Geotechnical Plan Review
Sharma Retaining Wall
7905 West Mercer Way
Mercer Island, Washington
NGA File No. 1496924

This letter presents the results of our geotechnical engineering review of the plans for the Sharma retaining wall project located at **7905 West Mercer Way in Mercer Way, Washington.**

PROPOSED SITE PLAN

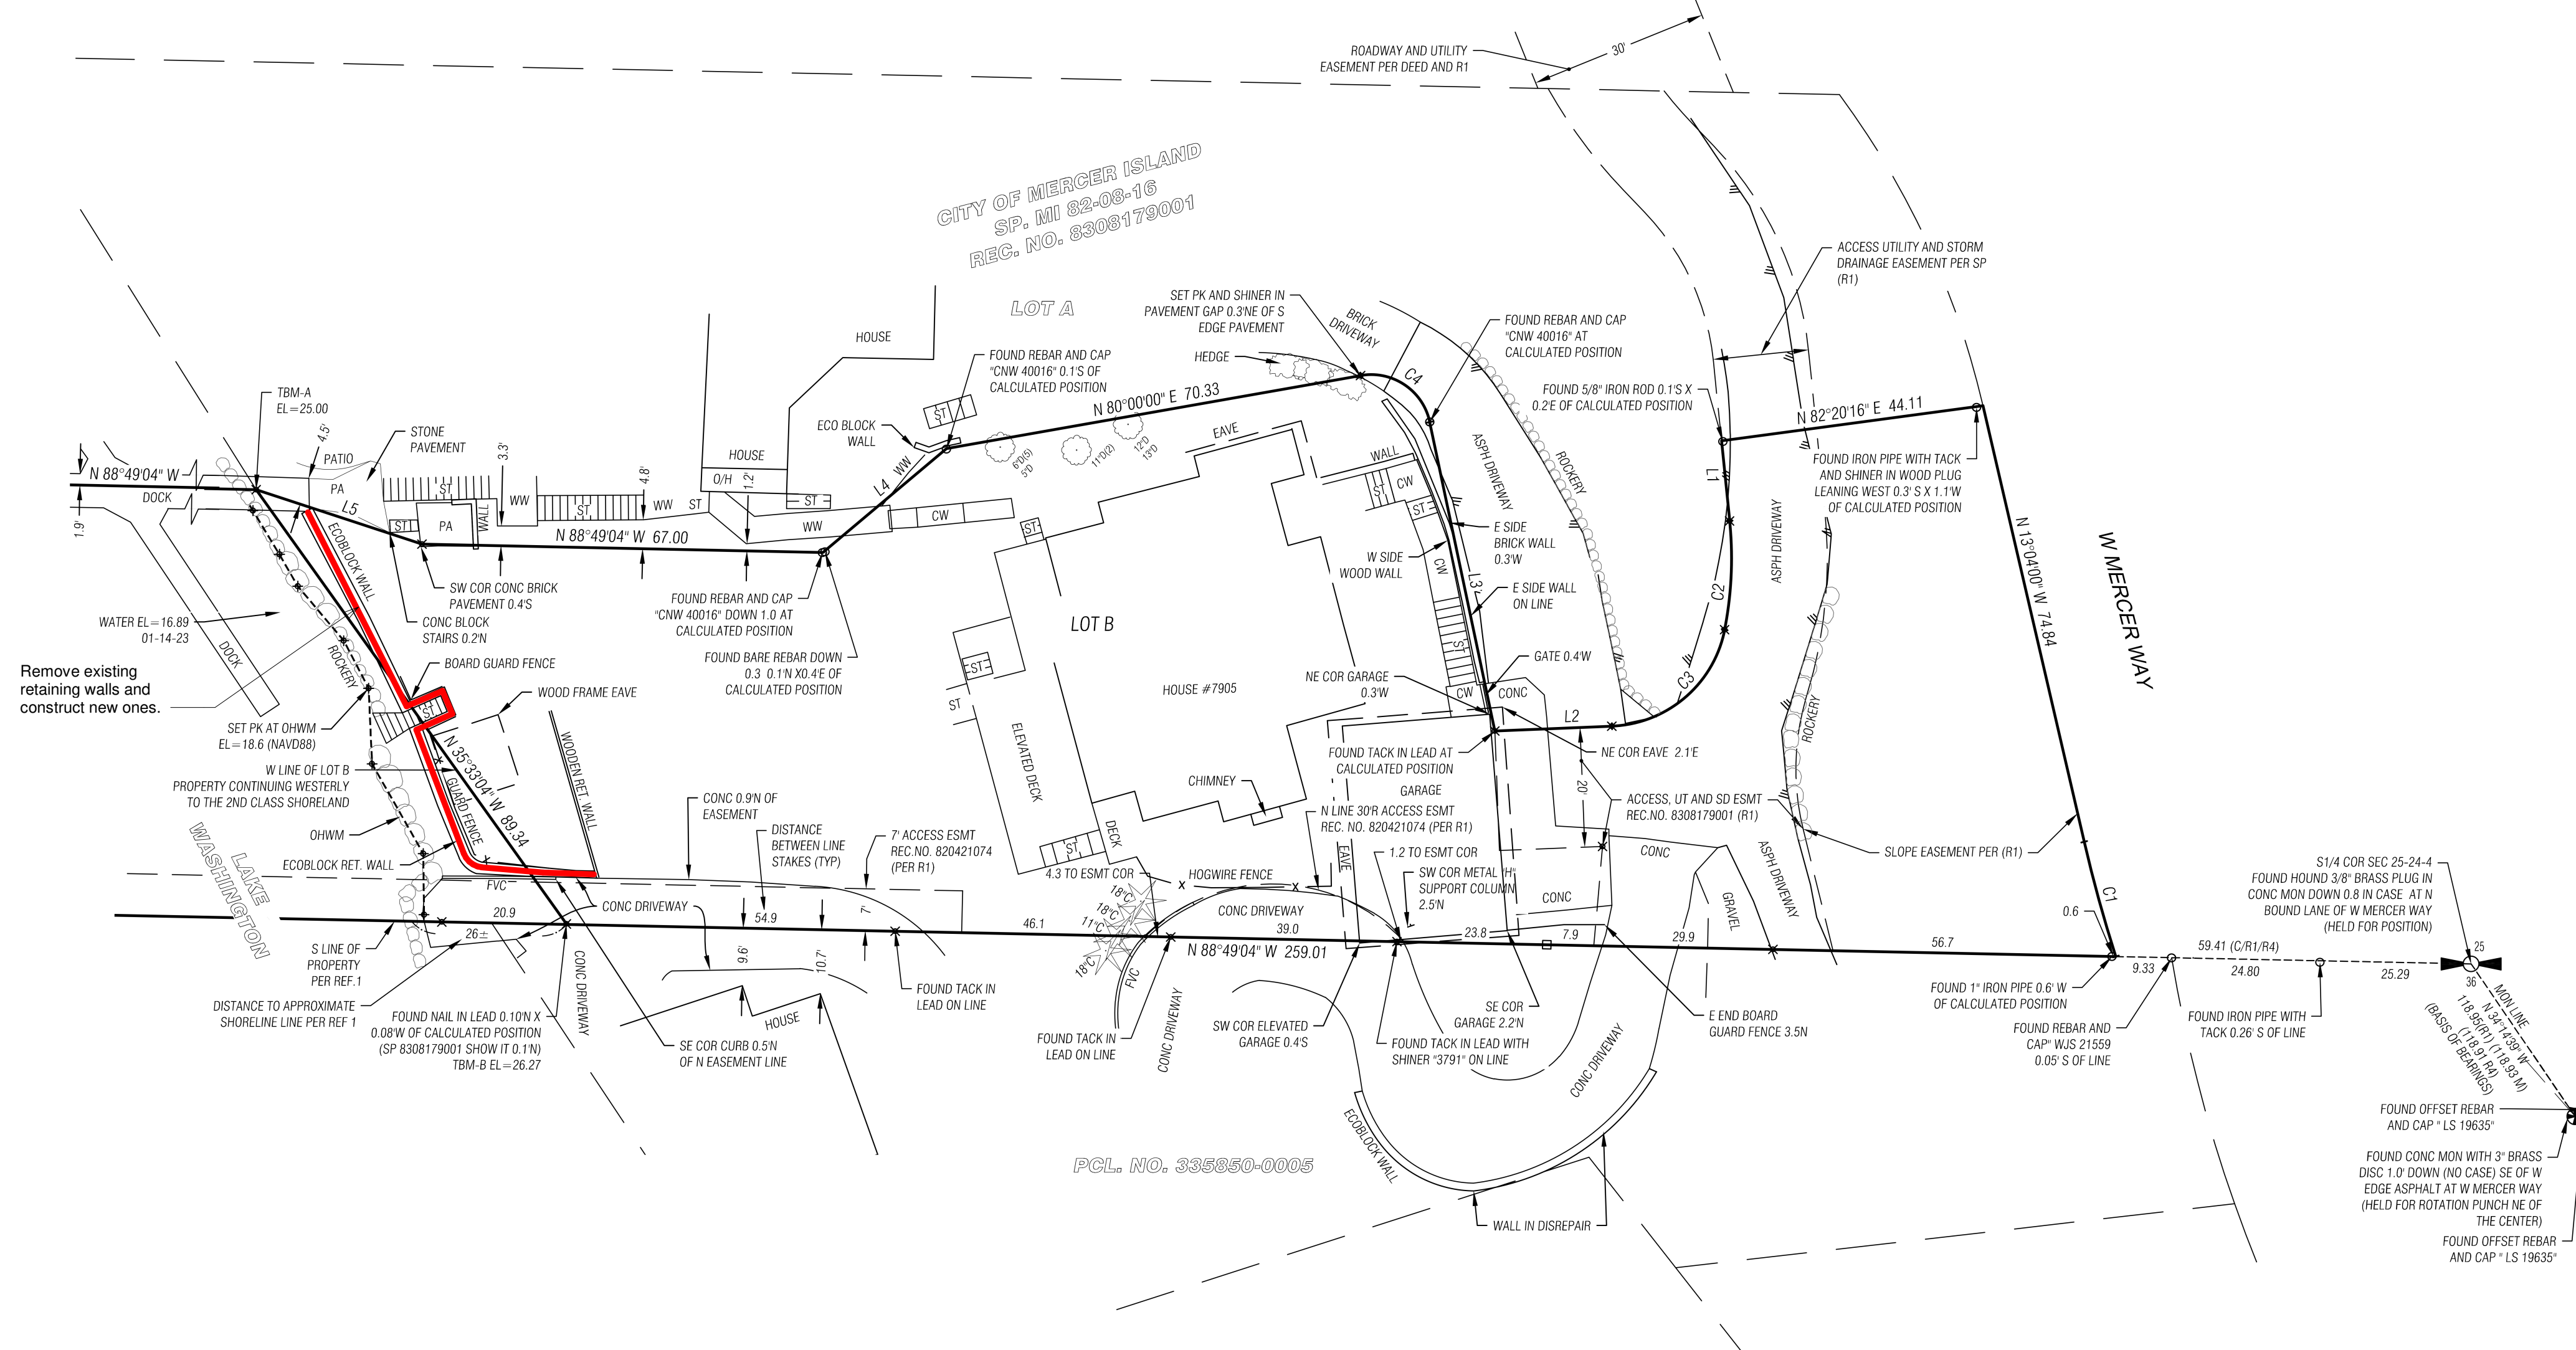
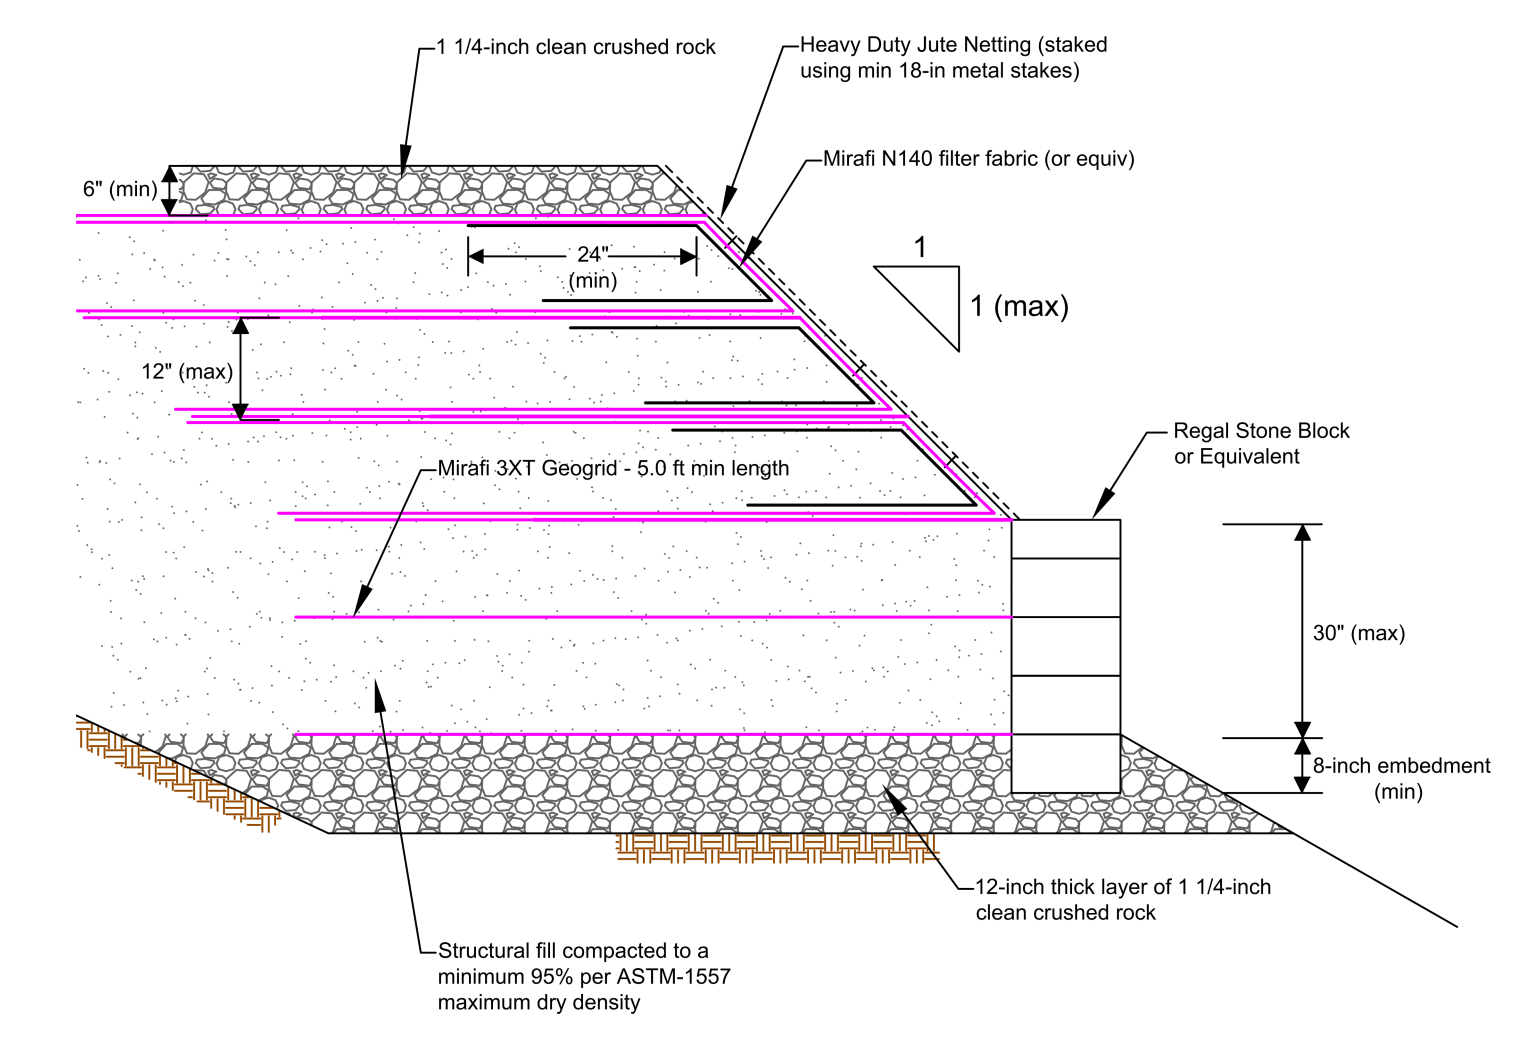
We have reviewed the geotechnical aspects of the provided updated plans and found the plans to be in general compliance with our recommendations as presented in our previous geotechnical report. Plans indicate that the new block wall will be located in the same footprint as the existing wall, but will have an exposed height of 30 inches, along with 8-inches of embedment. The base blocks will be placed on a 12-inch-thick pad of 1¼-inch clean crushed rock. All fill behind and above the wall will be placed as structural fill and is to be compacted to 95 percent of maximum dry density, per **ASTM-1557**. Fill behind the block wall will be reinforced with Mirafi 3XT geogrid placed every 12 inches and extending 5.0 feet from the back of the wall. The area above the wall will be sloped back at a 1 Horizontal to 1 Vertical (1H:1V) gradient, reinforced with Mirafi 3XT geogrid wraps lined with Mirafi N140 filter fabric or equivalent. The surface of the slope will be covered with heavy duty jute netting staked in place with metal steaks that are a minimum of 18 inches long. The top of the slope above the wall will be covered with 6 inches of compacted 1¼-inch clean crushed rock.

All other recommendations provided in our previous report should be strictly followed and all drainage from the new wall should be directed to an approved point of discharge.
